From: Tom Errico <thomas.errico@tylin.com>
To: Helen Donaldson <HCD@portlandmaine.gov>
CC: David Margolis-Pineo <DMP@portlandmaine.gov>, Jeremiah Bartlett <JBartlett@portlandmaine.gov>, Jeff Tarling <JST@portlandmaine.gov>, Katherine Earley <KAS@portlandmaine.gov>
Date: 12/10/2014 8:11 AM
Subject: 1210 Brighton Avenue - Hotel Project - Preliminary Traffic Comments

Nell - I have reviewed the site plan and application materials and offer the following preliminary traffic comments.

Job information table with fields: Job No. (257), Date (Nov. 14, 2014), Scale (1"=30'), Drawn (SWC), Checked (WRW), and Sheet No. (C2.0).

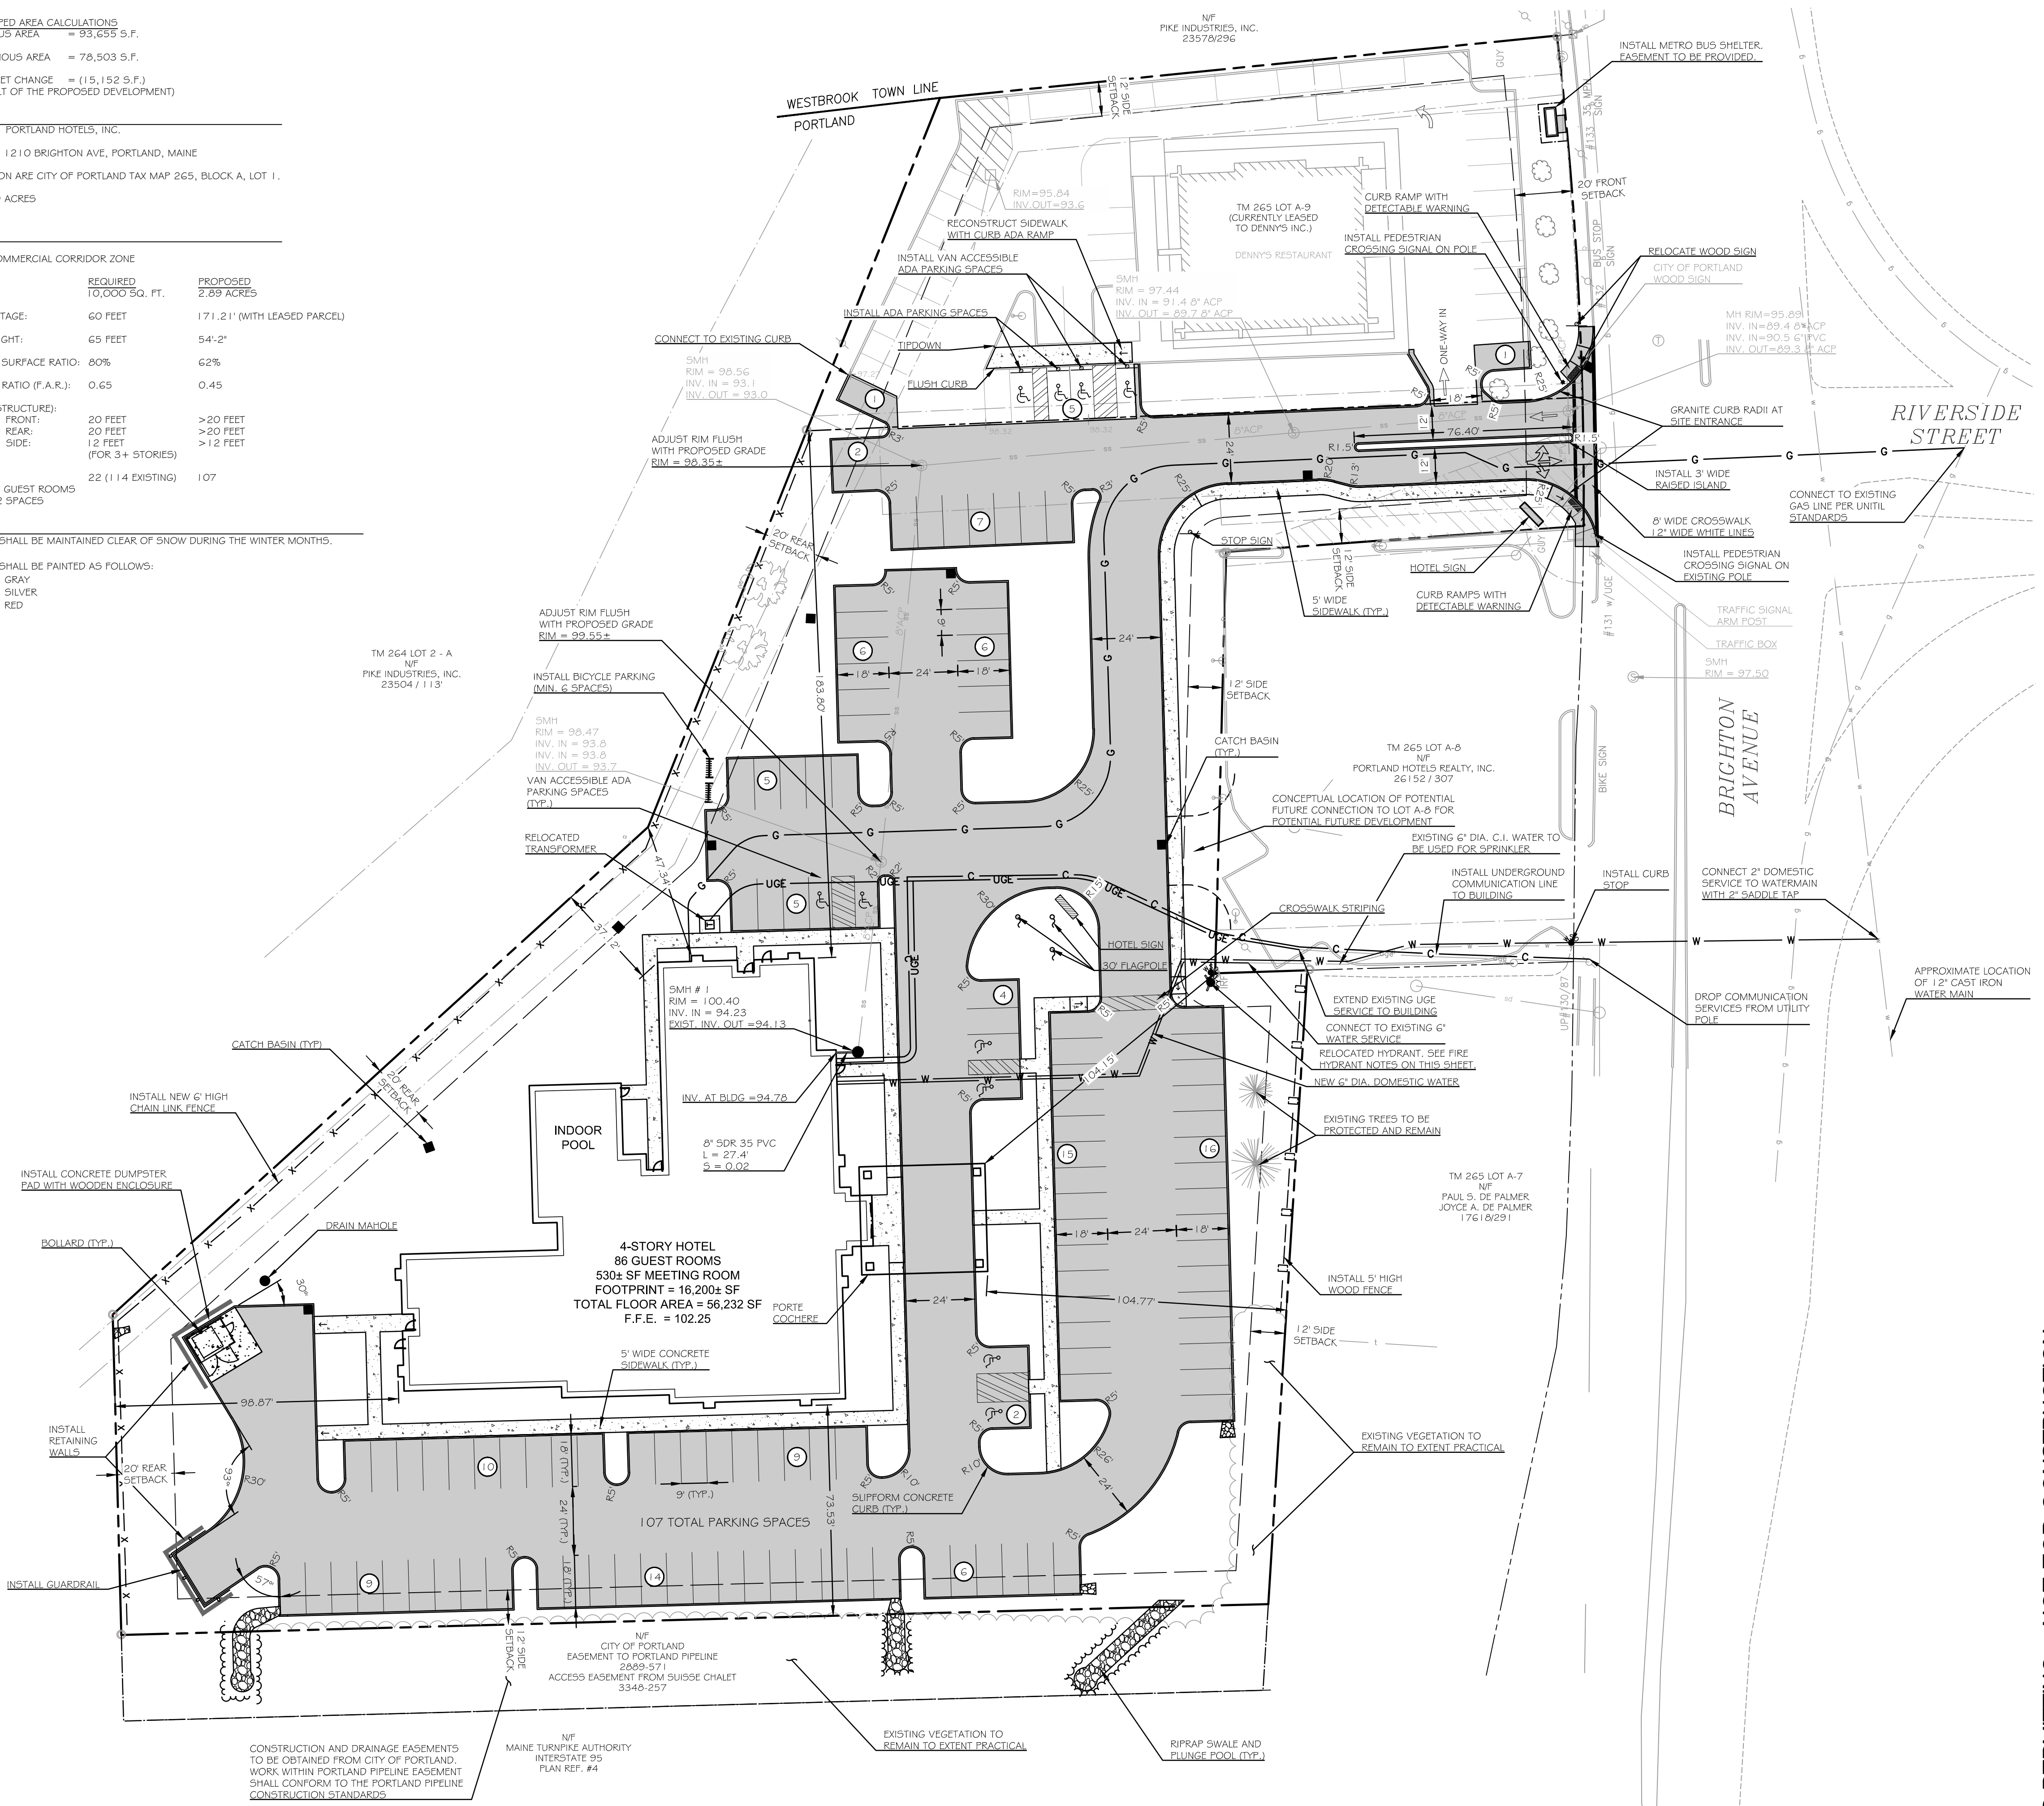
1. A crosswalk shall be provided on the driveway at Brighton Avenue and the traffic signal shall be upgraded to included pedestrian crossing signal equipment and be fully ADA compliant.

2. I do not find the location of the Denny's Restaurant parking spaces along the access driveway to be a safe condition and suggest that design options be considered that eliminated the direct backing maneuver conflicts that will occur under the proposed design.

3. The applicant shall coordinate with METRO on the provision of a bus shelter at the site driveway bus stop area.
4. I have reviewed the traffic analysis conducted by Bill Bray, PE and concur that the project will reduce traffic generation from the site and that the Brighton Avenue/Riverside Drive intersection does not exhibit safety concerns. A Traffic Movement Permit is not required.

5. The applicant should provide a study that supports the need for the parking supply provided.
6. The pedestrian routing for pedestrians between the proposed hotel building and destinations to Portland is indirect and the applicant should review a more direct connection.

7. The parking and circulation layout seems to be inefficiently designed from an excess pavement perspective and I would suggest the applicant consider revising the plan. One suggestion would be to combine the access road to the hotel and the 20 space parking area. This change could also help to reduce the number of pedestrian crossings.
